Reference: P/165/21/PL

Location: Land at Spinnaker View, Pagham, PO21 3FL

Proposal: New vehicular access entrance, relocated parking bays, and pedestrian access associated with the redevelopment of the rear of Inglenook Hotel as 9no. dwellings. This application is in CIL Zone 4 (zero rated) as other development. This application may affect the setting of a Grade II Listed Building

Mark Warwick
Tree Officer / Greenspace

Drawing Title	Site Layout
---------------	-------------

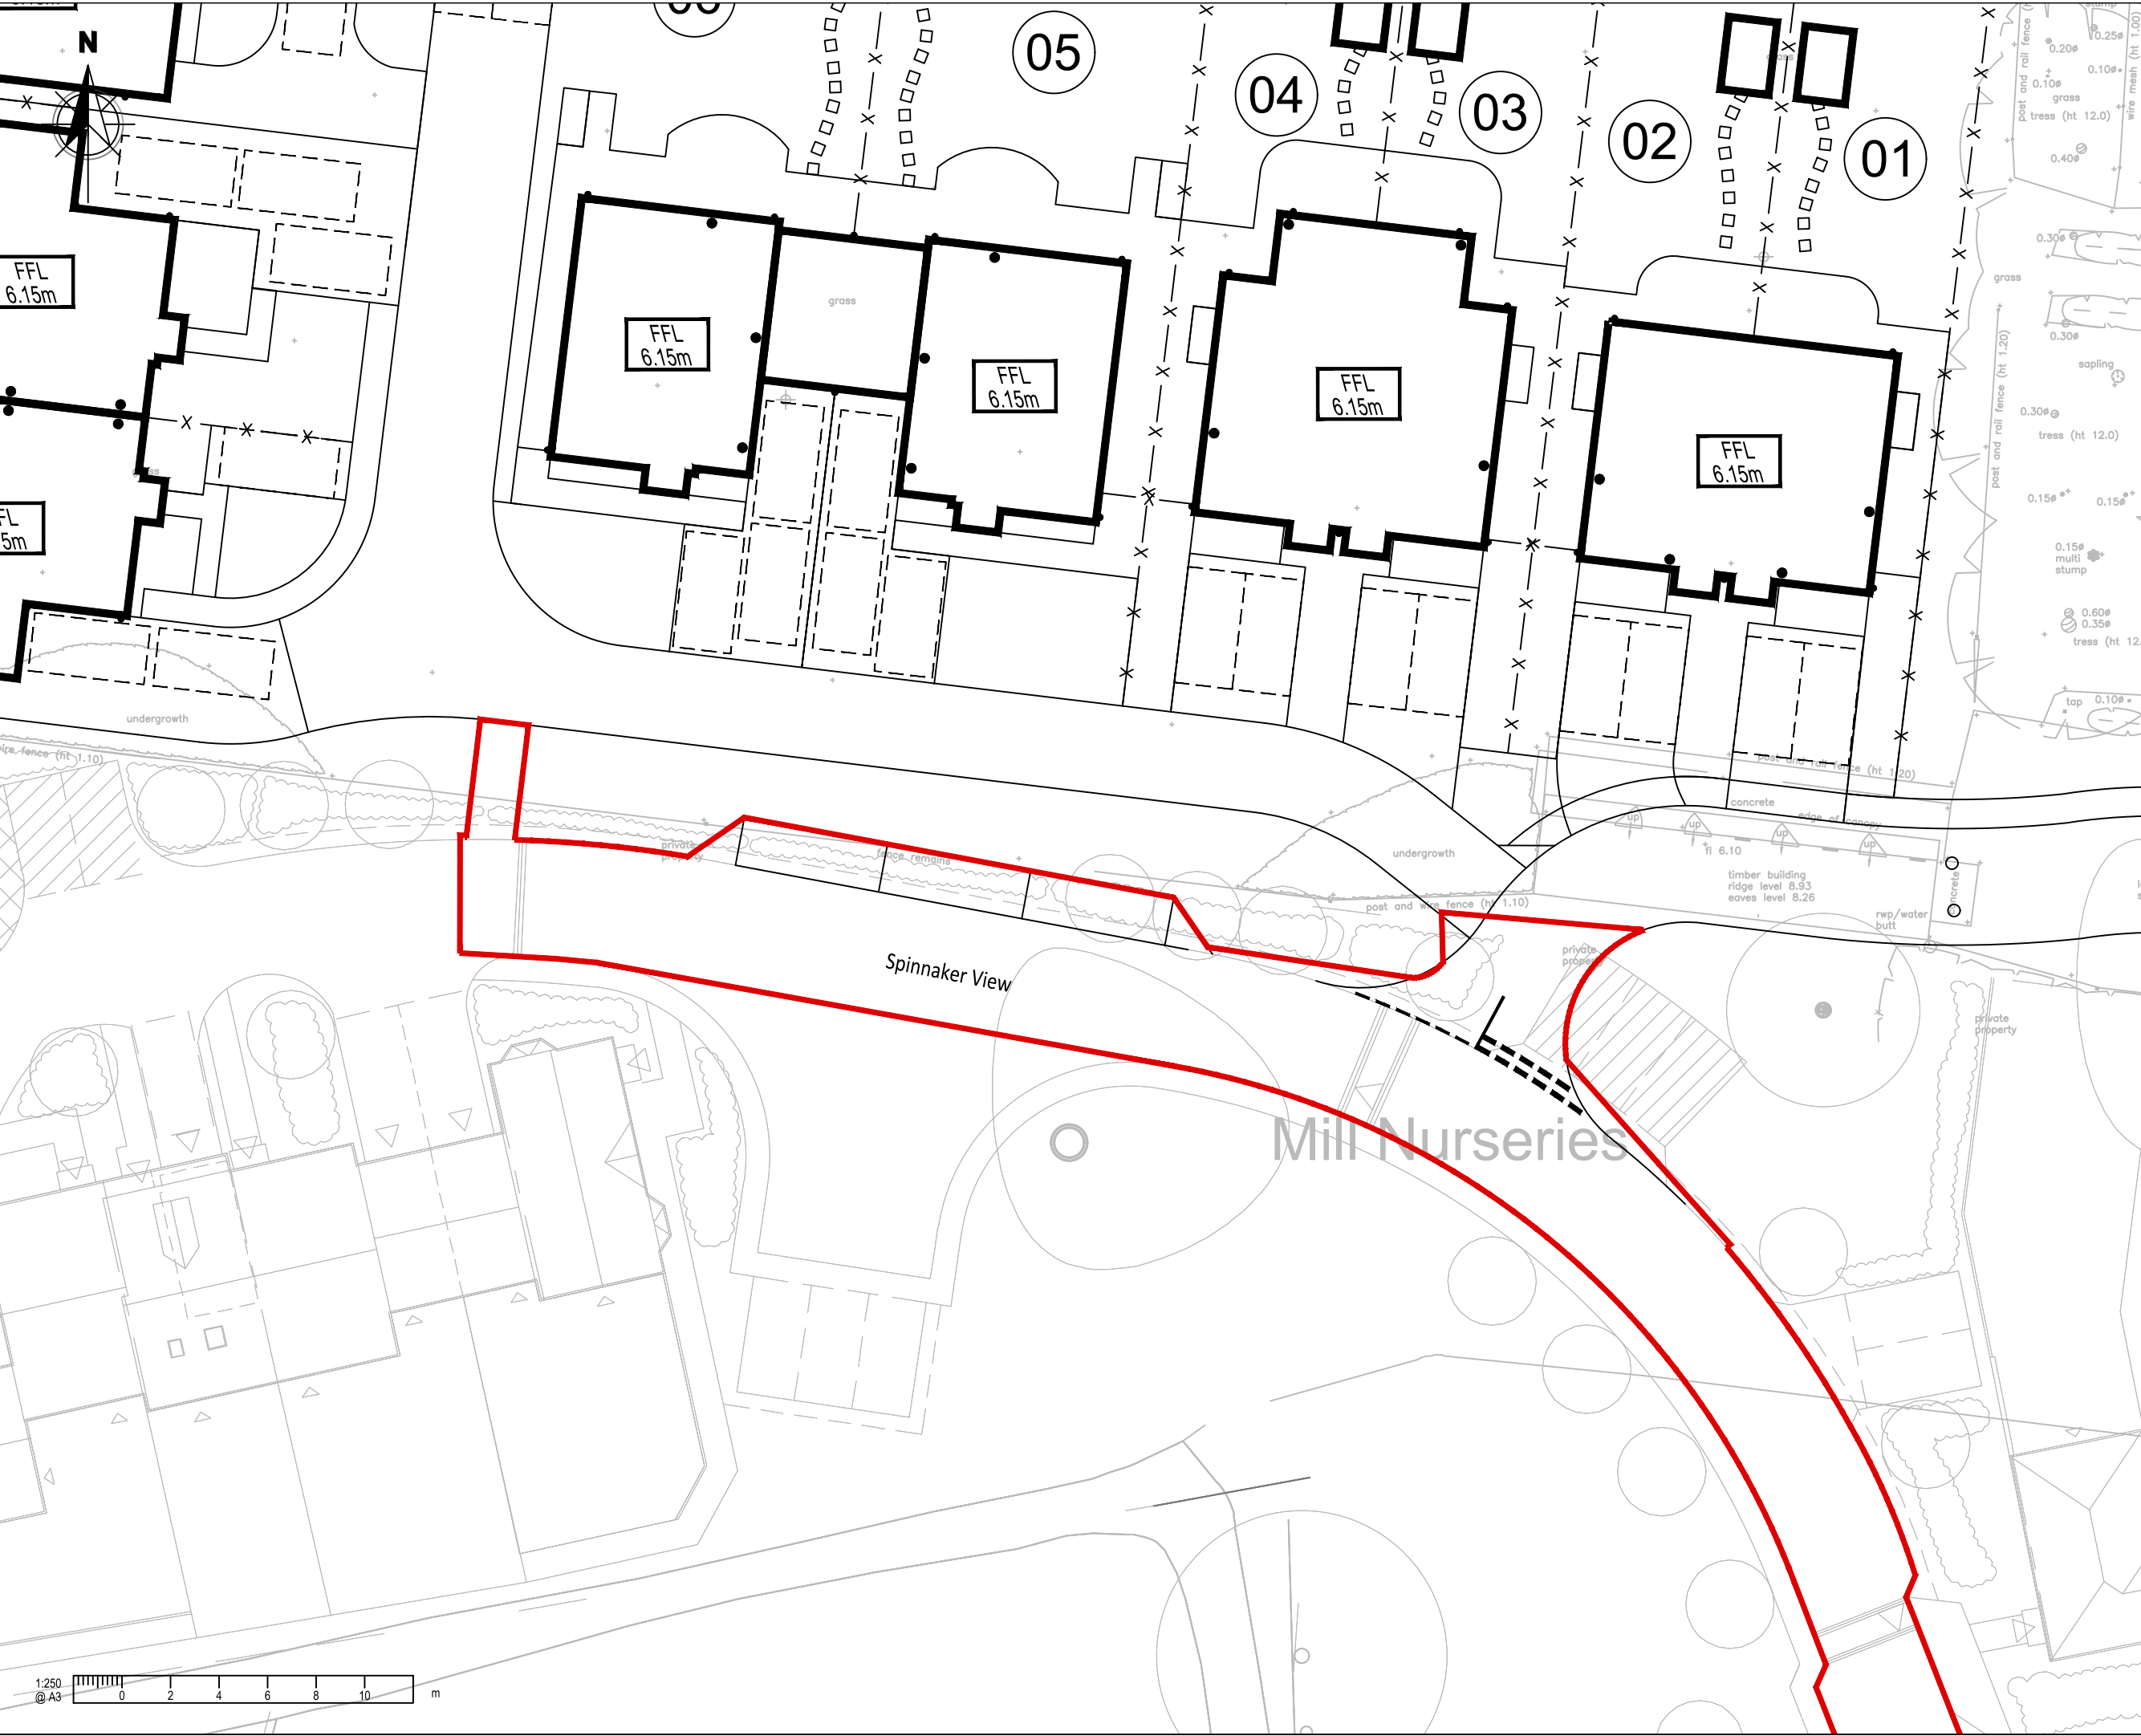
- A large poplar to the south and at western end overlaps the site. A previous arboricultural report submitted with application P/125/14/PL determined a nominal root protection area (RPA) that extends far N to beyond the site perimeter. Demolition and construction are proposed within the RPA. This work needs to be closely supervised by a project arboriculturist to ensure the existing specialised carriageway construction is not disturbed (I recommend the applicant familiarise themselves with the Arboricultural Impact Assessment submitted under the above reference).

- Several standard trees and hedgerow plants are establishing in areas identified for construction, so need to be assessed for potential transplanting to elsewhere on the site (locations subject to our approval) or their loss compensated for within a new scheme of planting nearby and to provide some visual benefit to those it was originally intended for.

1. The applicants will need to employ the services of an Arboricultural Consultant to carry out a tree survey exercise and then prepare an Arboricultural Impact Assessment (AIA) which must be inclusive of; a 'Tree Survey Schedule', a 'Root Protection Area (RPA) Schedule' and a 'Tree Constraints Plan' – with the trees accurately plotted on same.

2. In the event that an RPA of any tree which is proposed for retention overlaps the development then BS5837:2012 requires that the Detailed Planning Application is accompanied by an Arboricultural Method Statement (AMS) and also most importantly a Tree Protection Plan – to both describe and illustrate the mitigation measures which are to be employed to ensure that the trees survive without detriment to their vigour and vitality and are given adequate protection both above and below ground.
